## **Development Facilitation Team (DFT) – Review Comments**

**Project No: PR-2022-006746      Date: 06/21/2023      Agenda Item: #3 Zone Atlas Page: H-11**

**Legal Description: PROPOSED REPLAT OF LOTS A24, A26, A26 IN VISTA MAGNIFICA SUBDIVISION. GOAL: TURN CURRENT THREE LOTS INTO TWO LOTS, AND FACING NEW DIRECTIONS.**

### **Application For: PS-2023-00101-SKETCH PLAT (DFT)**

PLAT OF SURVEY
LOTS A24, A25 & A26, BLOCK 4
VISTA MAGNIFICA SUBDIVISION
CITY OF ALBUQUERQUE
BERNALILLO COUNTY, NEW MEXICO

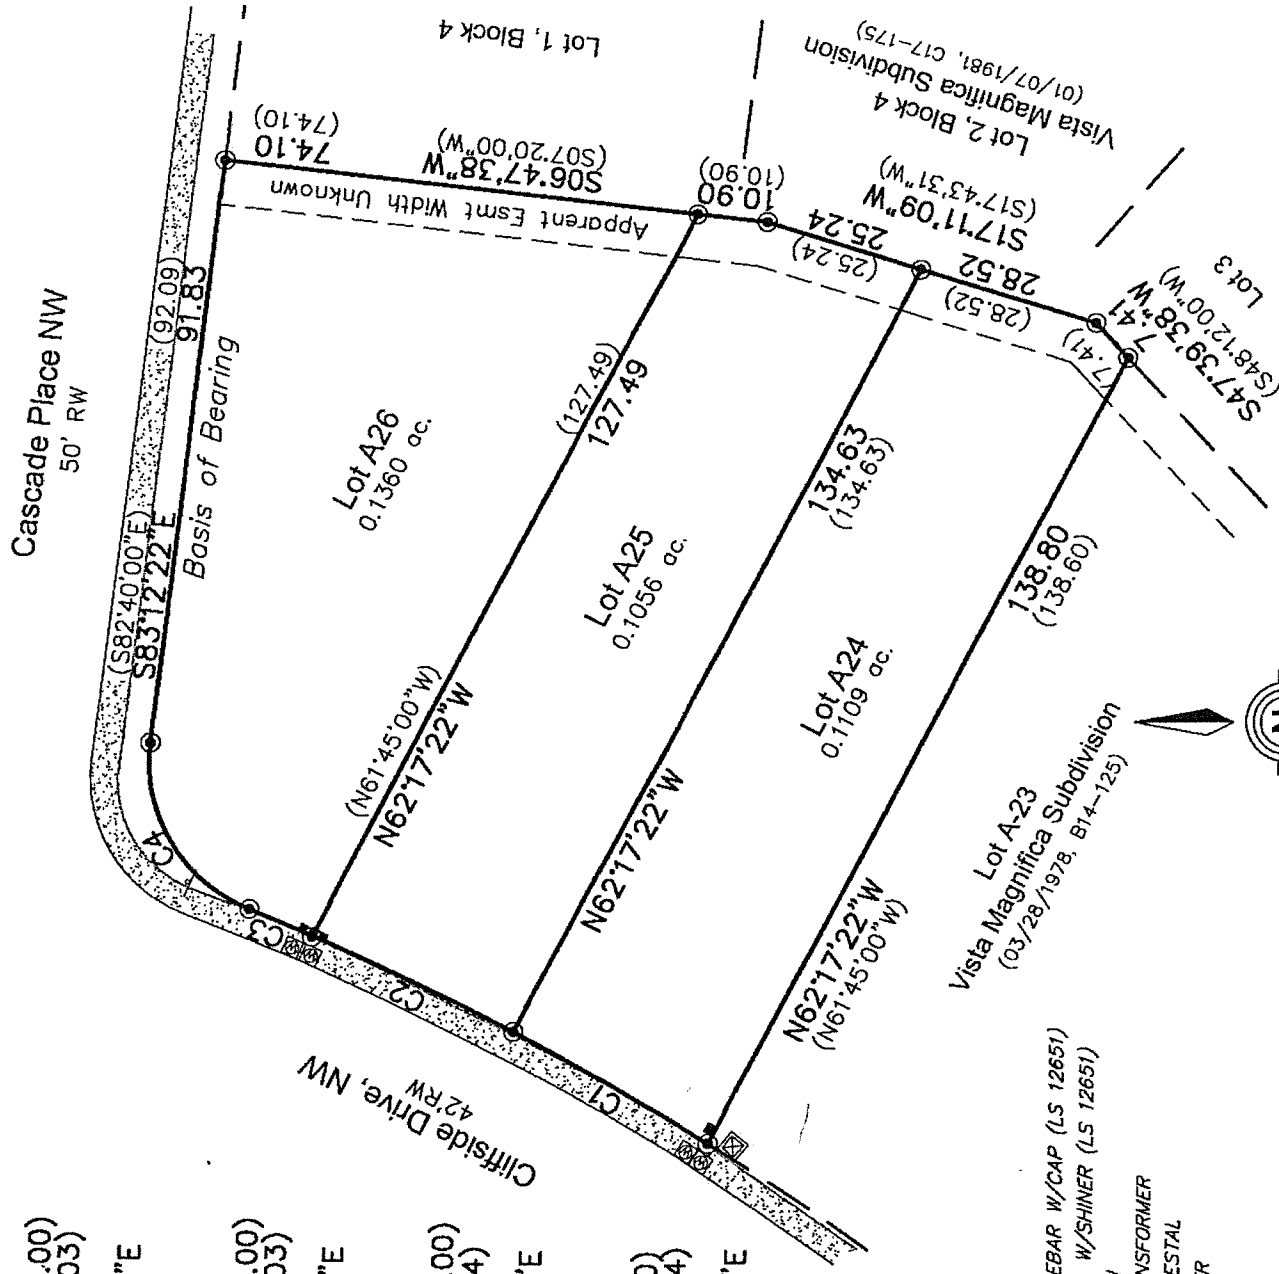
1. There are existing services off Cliffside that serve three lots. Any water services that will not be utilized will need to be abandoned by cutting it back to the main and stopping it at the corporation stop.
2. The lot along Cliffside will have 3 meters box locations available to the site and what looks like sanitary sewer services as well.
3. New services can be provided along Cascade but it looks like they potentially all came from Cliffside.
4. Any services that will need to be preserved will need easements to reach the new proposed Lot A-26-B crossing Lot A-26-A.
